**Re: PA22-015 - Colvin PRD – Technical Review 1  
CORE Project No. 21387**

The purpose of this letter is to provide a response to the review comments for PA22-015 - Colvin PRD – Technical Review 1 dated December 14, 2022. We have addressed each comment and revised the plan/documentation accordingly. This letter contains the review comments immediately followed by our response to each in bold lettering.

MAINVUE WA, LLC
 1110 112TH AVE NE, STE 202
 BELLEVUE, WA 98004

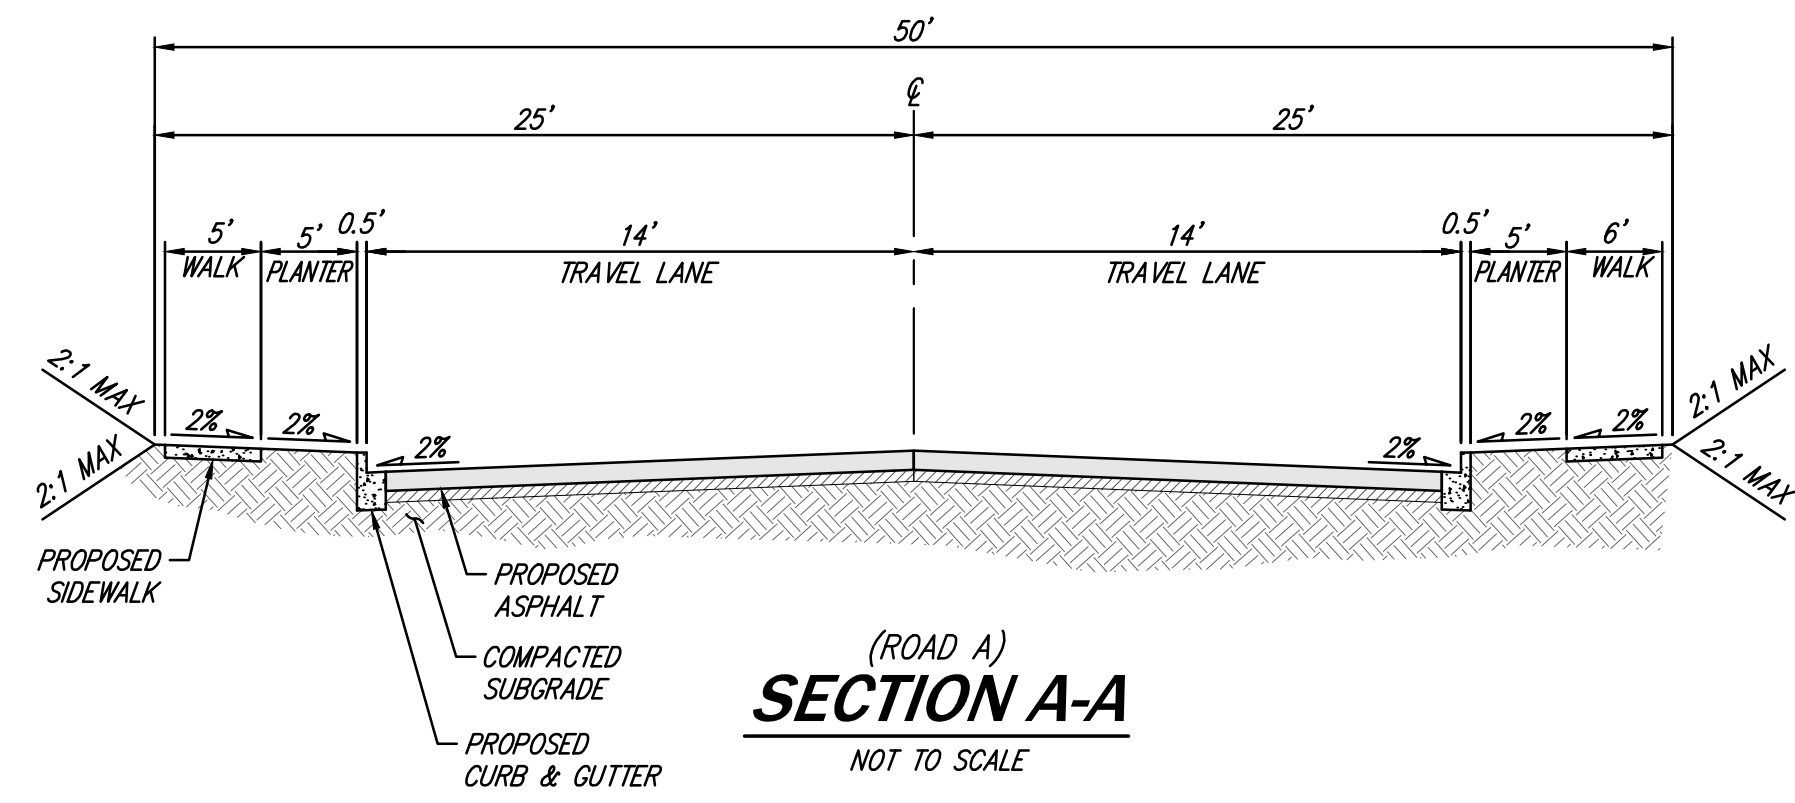
21. 15' Easement will be needed for storm run between CB4-CB5.

22. Should be considered bypass in the drainage model.

23. 5' private drainage easement needed for these wall drains.

24. Should be considered bypass in the drainage model.

25. These must be thru-curb inlets.

26. How is the upstream flow being collected and routed through the site.

***Response: An easement has been added as requested.***

***Response: This area has now been considered as bypass. Please review report and plans.***

***Response: Easement has been added per request.***

***Response: This area has now been considered as bypass. Please review report and plans.***

***Response: Revised as requested.***

***Response: Information regarding this has now been added to this sheet and sheet C4.25.***

SHEET **C4.31** OF **7**

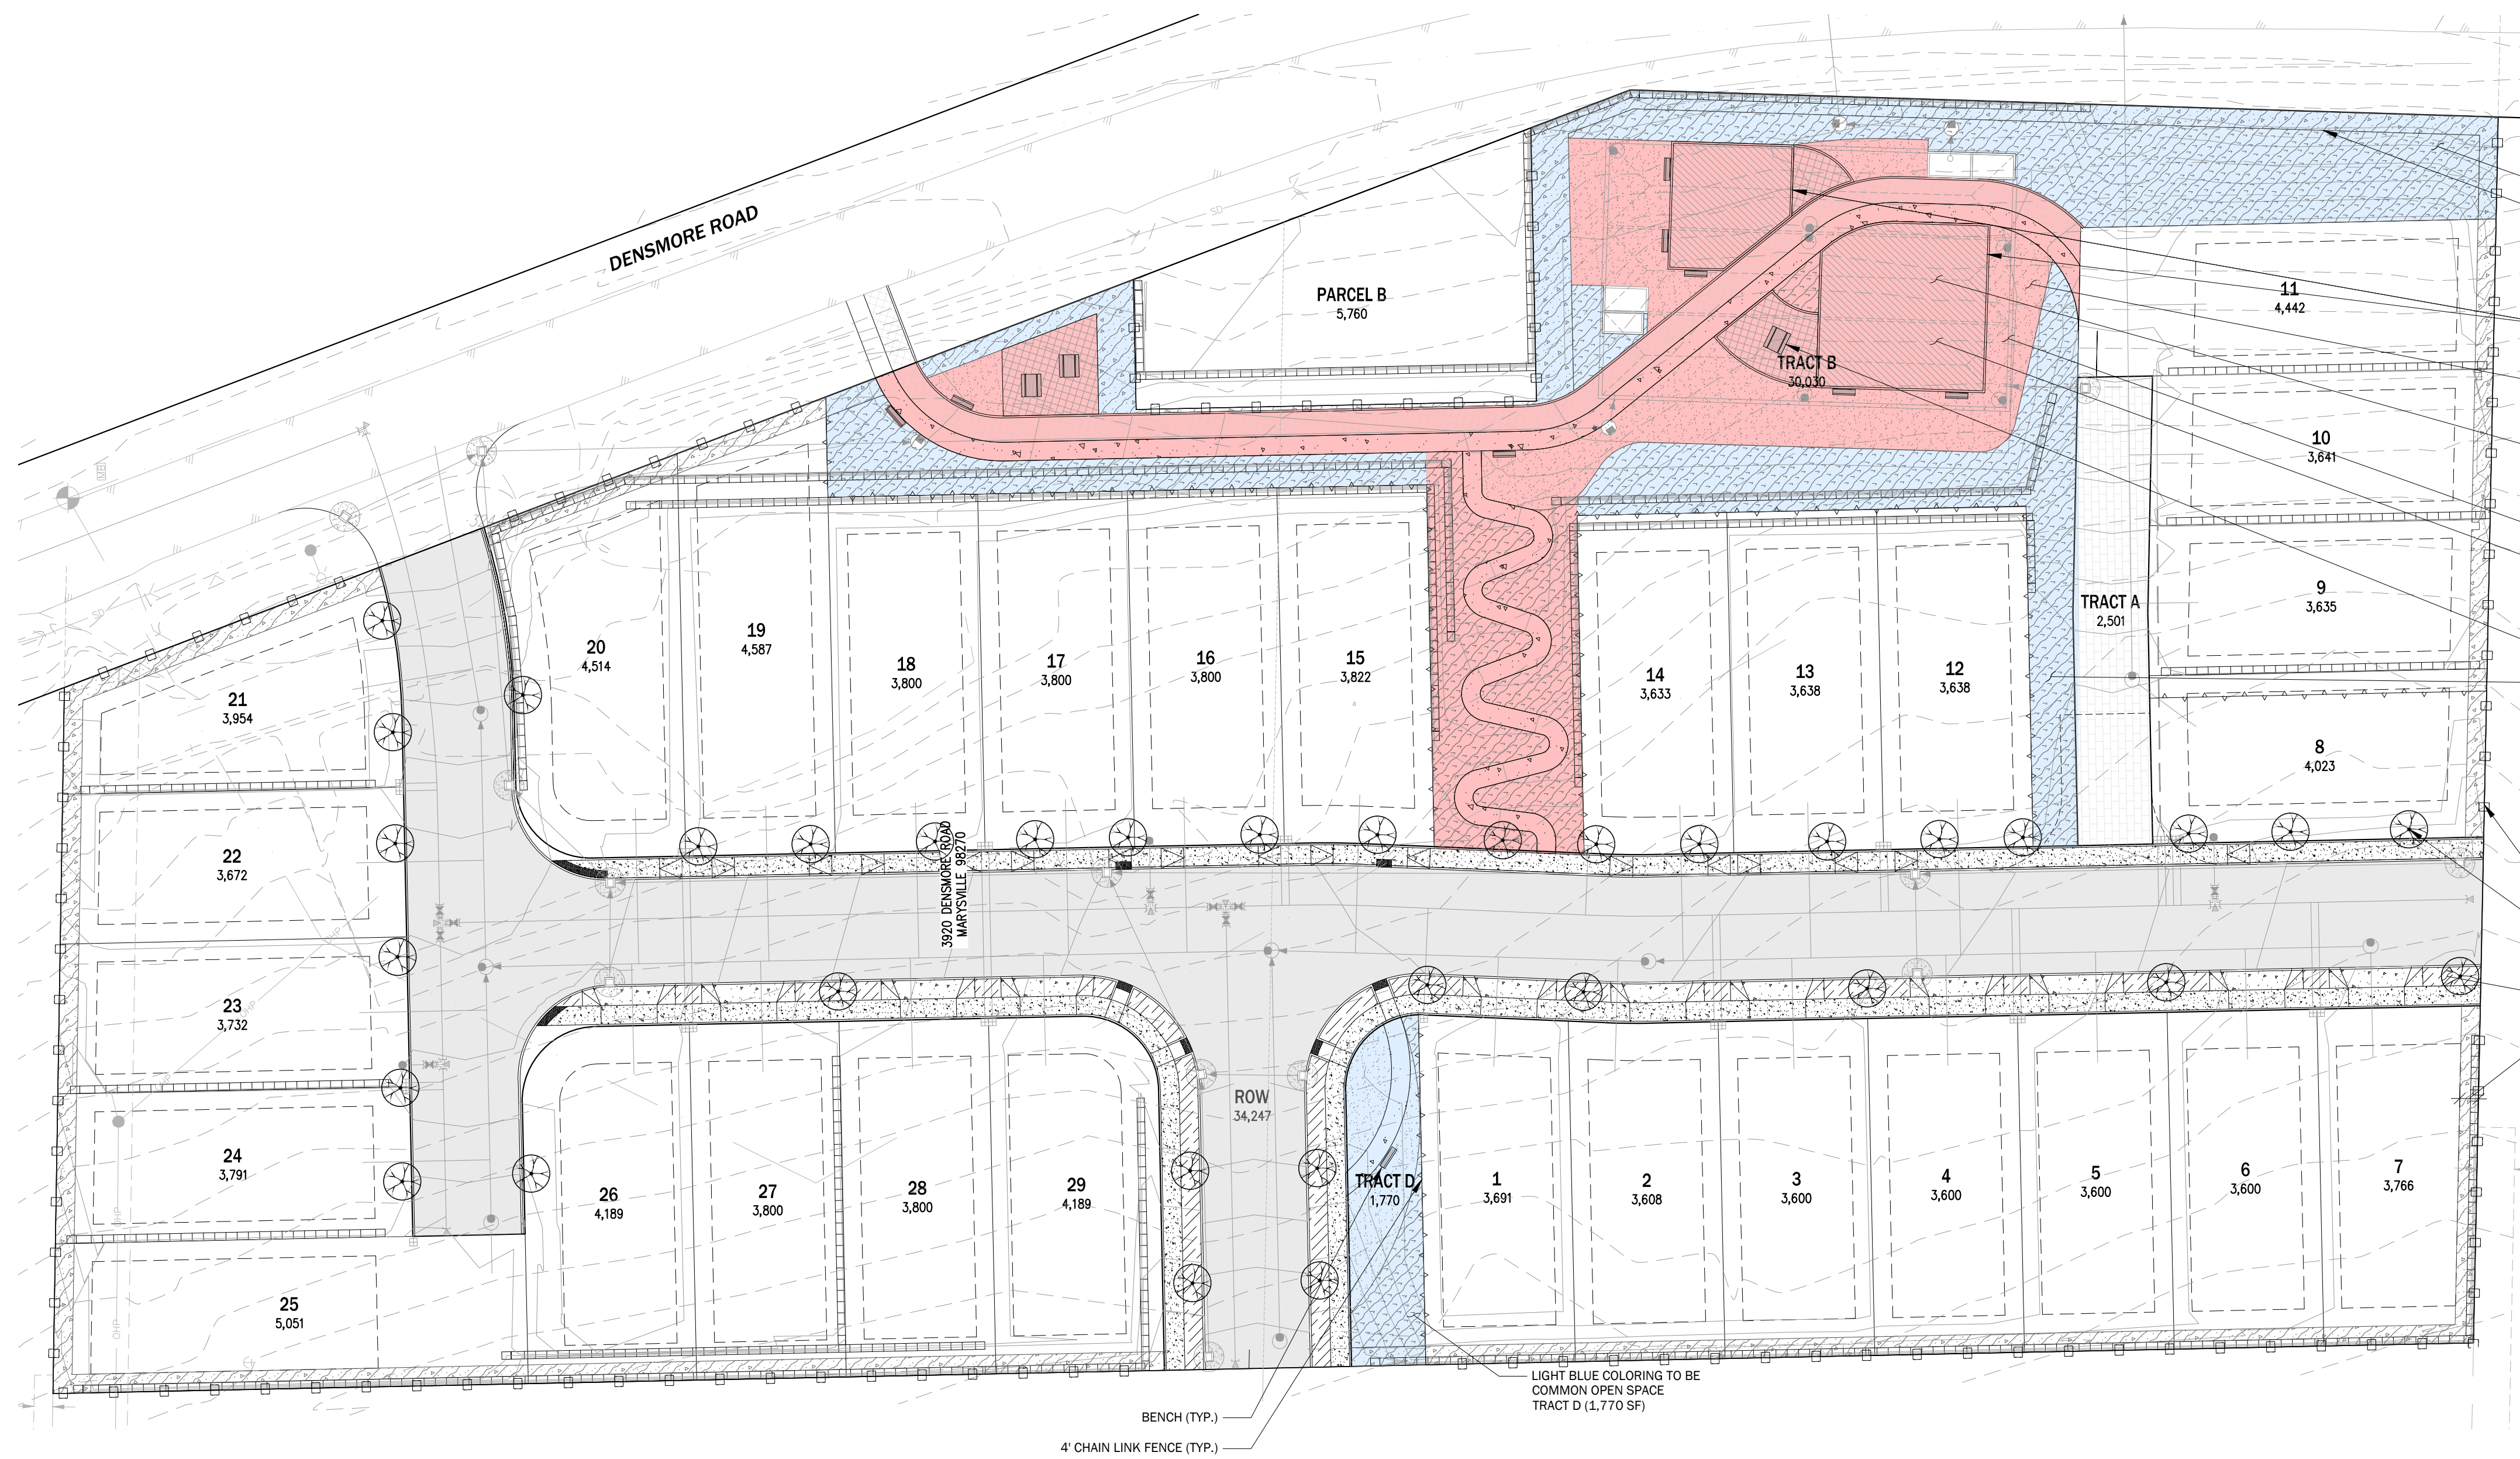
27. Not familiar with a 6'x11' access grate. Please provide manufacturers cut sheet or revise to 5'x10'.

***Response: Access grates now proposed to be 5'x10'.***

SHEET **L2.01** OF **7**
 PROJECT NUMBER **21387**

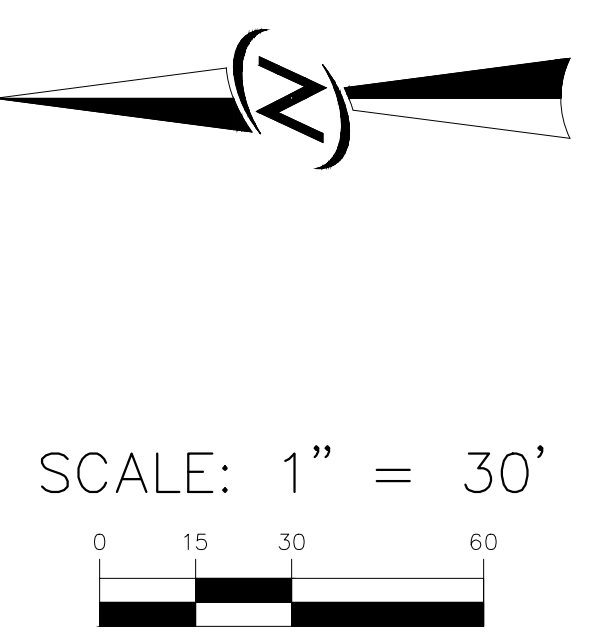
2. Per MMC 22C.120.140(2)(a), street trees are required along city streets and access easements. Update landscaping plan to include street trees along Tract C and D.

3. Based on the proposed height of the retaining wall along the east boundary adjacent to Densmore, revise landscape plan to include some landscaping, such as trees, along the base of the wall to provide some alleviation from massing.

***Response: Please review the revised landscape plans.***

***Response: Please review the revised landscape plans.***
